Rezoning Transportation Analysis

Petition Number: 2021-101

Date	Description
08-20-2021	First Review (KP)
02-23-2023	Second Review (PDM)

**RZ - 1.0**

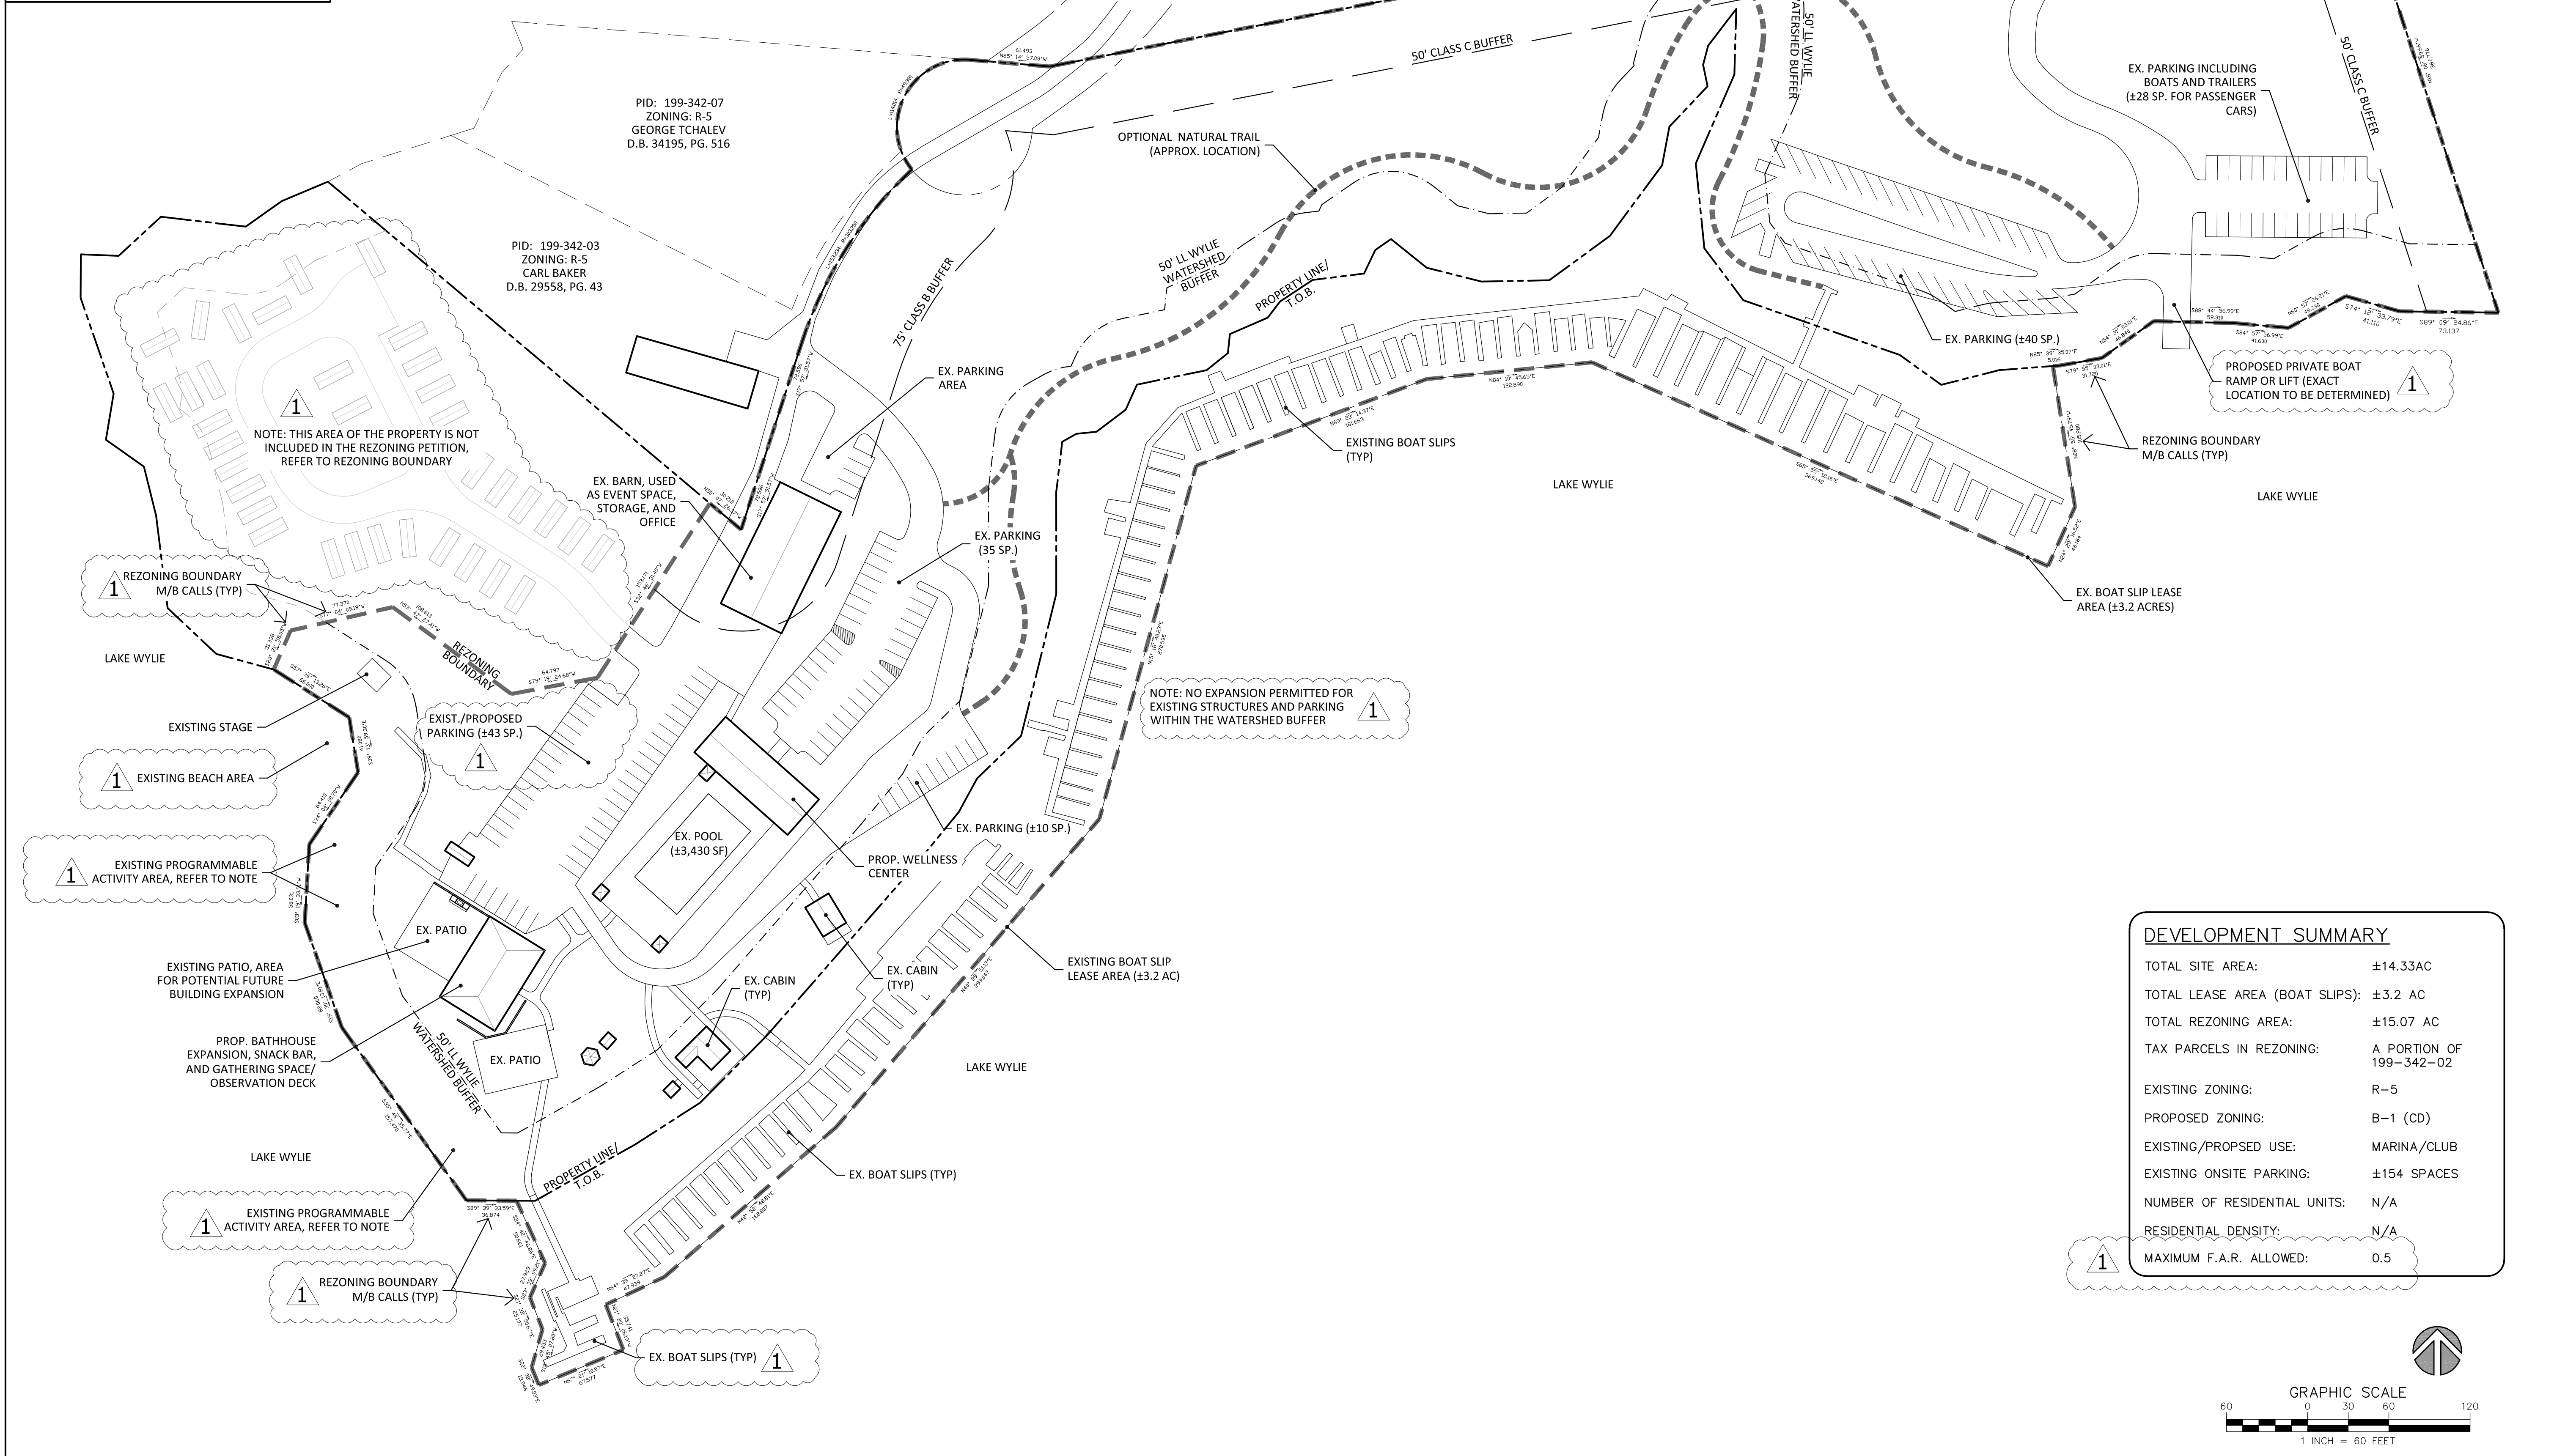
- OUTSTANDING COMMENT FROM 08-20-21:** Revise Rezoning sheet RZ-1.0 to show the entire segment of Rainbarrel Road from the rezoning boundary to the terminus at Pine Harbor Drive. Label and dimension the right-of-way dimensions on the public portion of Rainbarrel Road and label and dimension the access easement on the private portion of Rainbarrel Road.

- OUTSTANDING COMMENT FROM 08-20-21:** Revise the site plan and conditional notes to commit to coordinate with the property owners, along the private segment of Rainbarrel Road, to provide suitable and feasible traffic calming measures along this private segment of Rainbarrel Road.

- OUTSTANDING COMMENT FROM 08-20-21:** Revise the site plan and conditional notes to commit to improve the public portion of Rainbarrel Road to City Standards in accordance with the CLDSM USDG U-02, Local Residential Medium, cross section.

- OUTSTANDING COMMENT FROM 08-20-21:** Revise the site plan and conditional notes to commit to improve the private portion of Rainbarrel Road in accordance with the Typical Private Street Section Detail, 11.13, in within the CLDSM.

- NEW COMMENT FROM 02-23-23:** Provide clarification to note regarding security gate. Add note that gate will not be installed within public ROW.
 - The Petitioner reserves the right to install a security gate to limit access only to authorized persons.
